Planning Department
Brennon Williams, Director

**Re: Sunport Apartments - 2601 Mulberry SE
Erosion and Sediment Control Plan
Engineer's Stamp Date: Missing (M15E036)**

Based upon the information provided in your submittal received 7/6/2020, the above referenced plan can't be approved until the following comments are addressed:

SUNPORT APARTMENTS
FIRE 1 SITE PLAN
ALBUQUERQUE, NM
PROJECT #1844

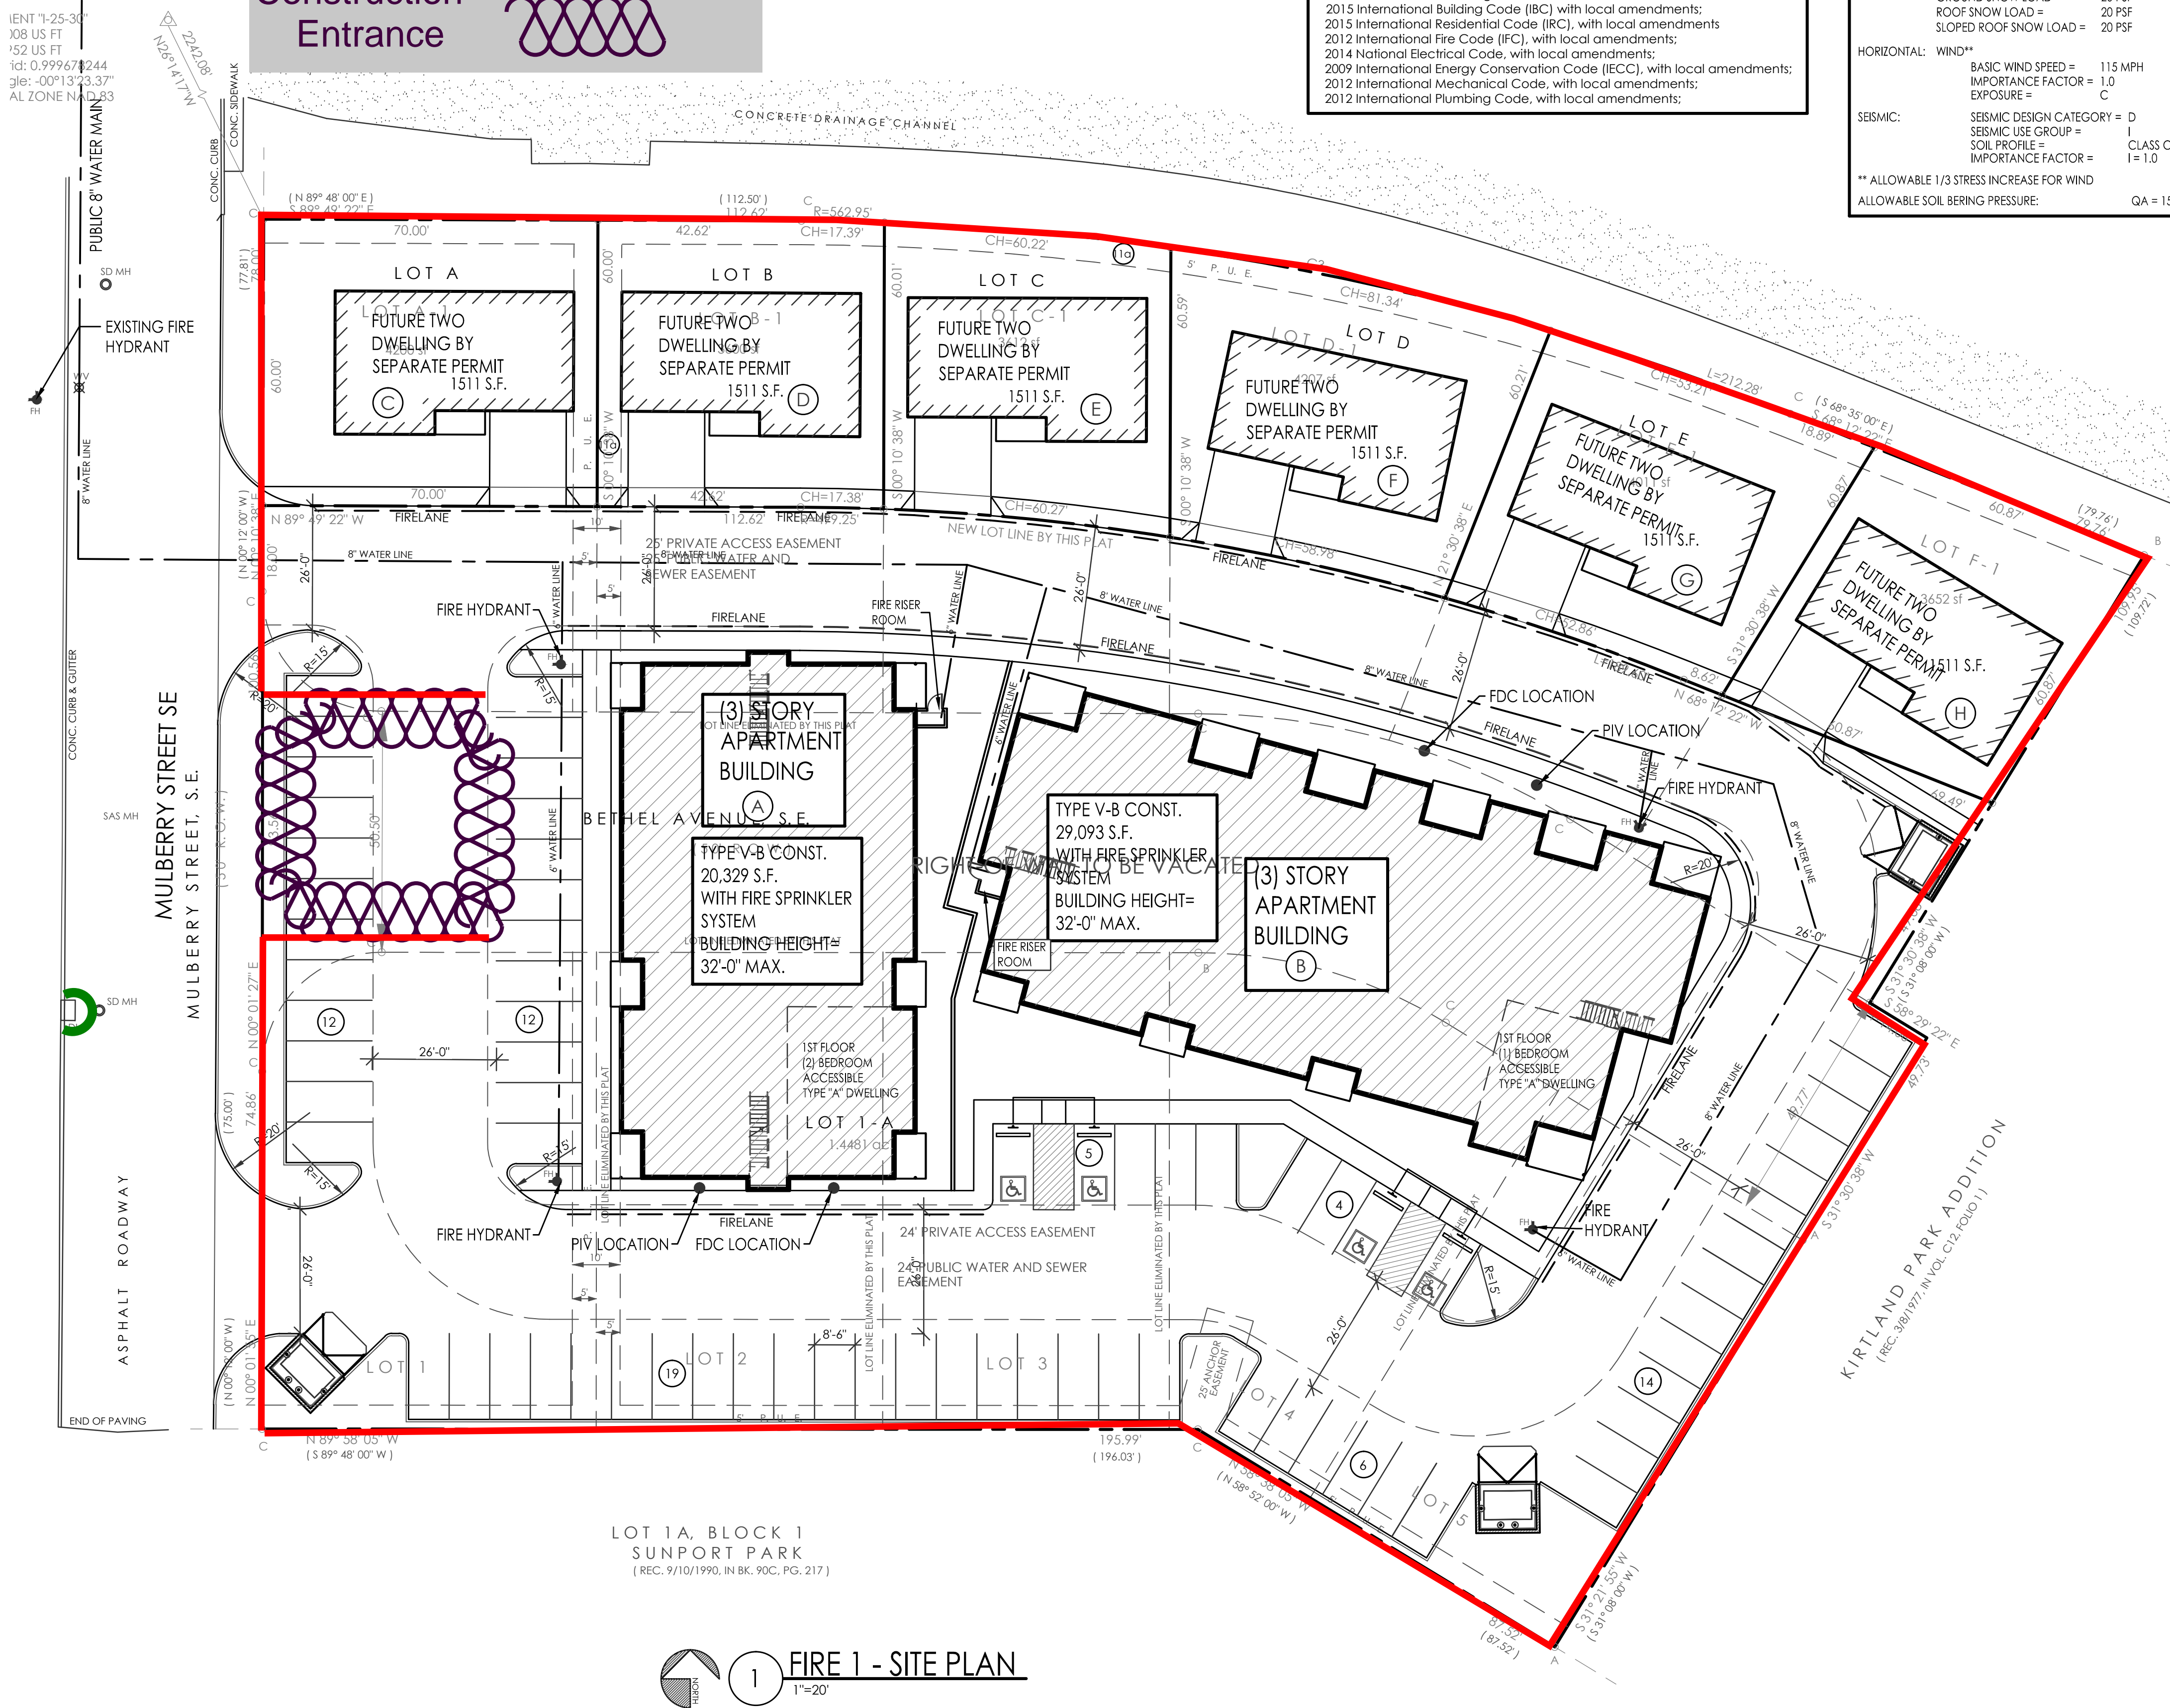
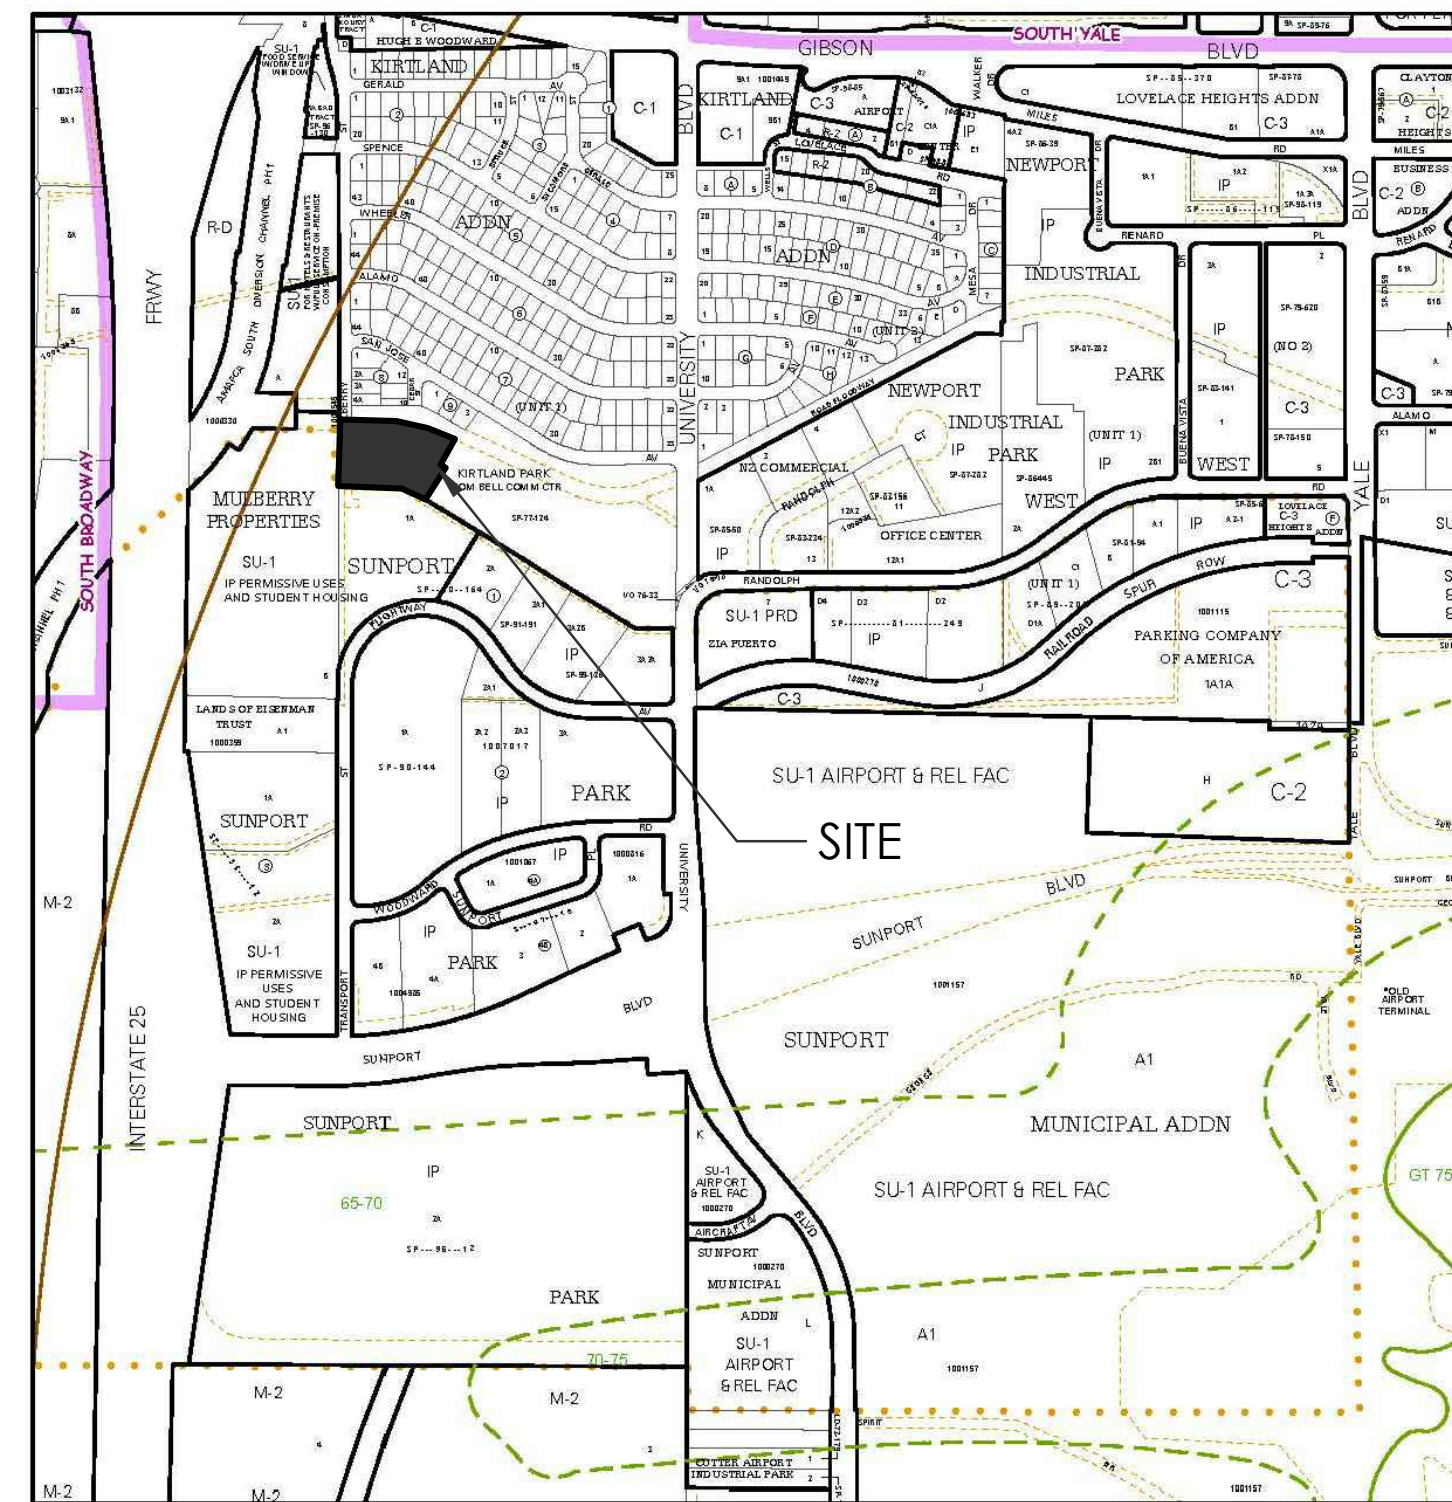
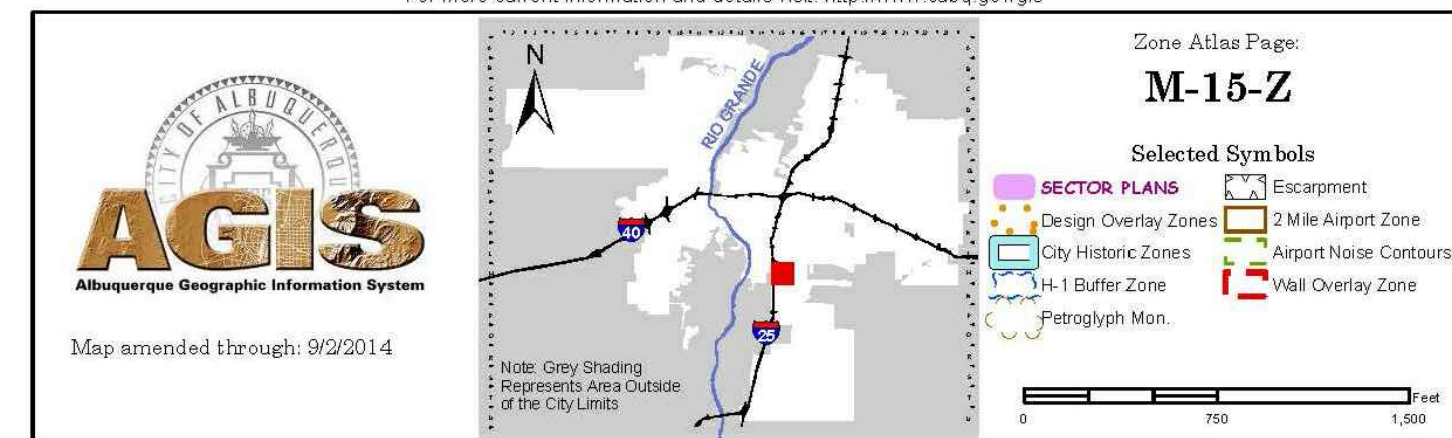
1. The ESC plan must agree with the approved G&D Plan (attached).
2. Add stamp and signature of a PE or CPESC.
3. Show existing and proposed grades (contours and/or spot elevations).

4. Show limits of disturbance.
5. Add inlet protection.
6. Move silt fence to back of existing C&G.
7. Add temporary sediment traps on the low side of this development. The pond shown on the approved G&D Plan may serve that purpose. Please add a note to the plan stating "the ponds are to be the first item of earthwork construction"
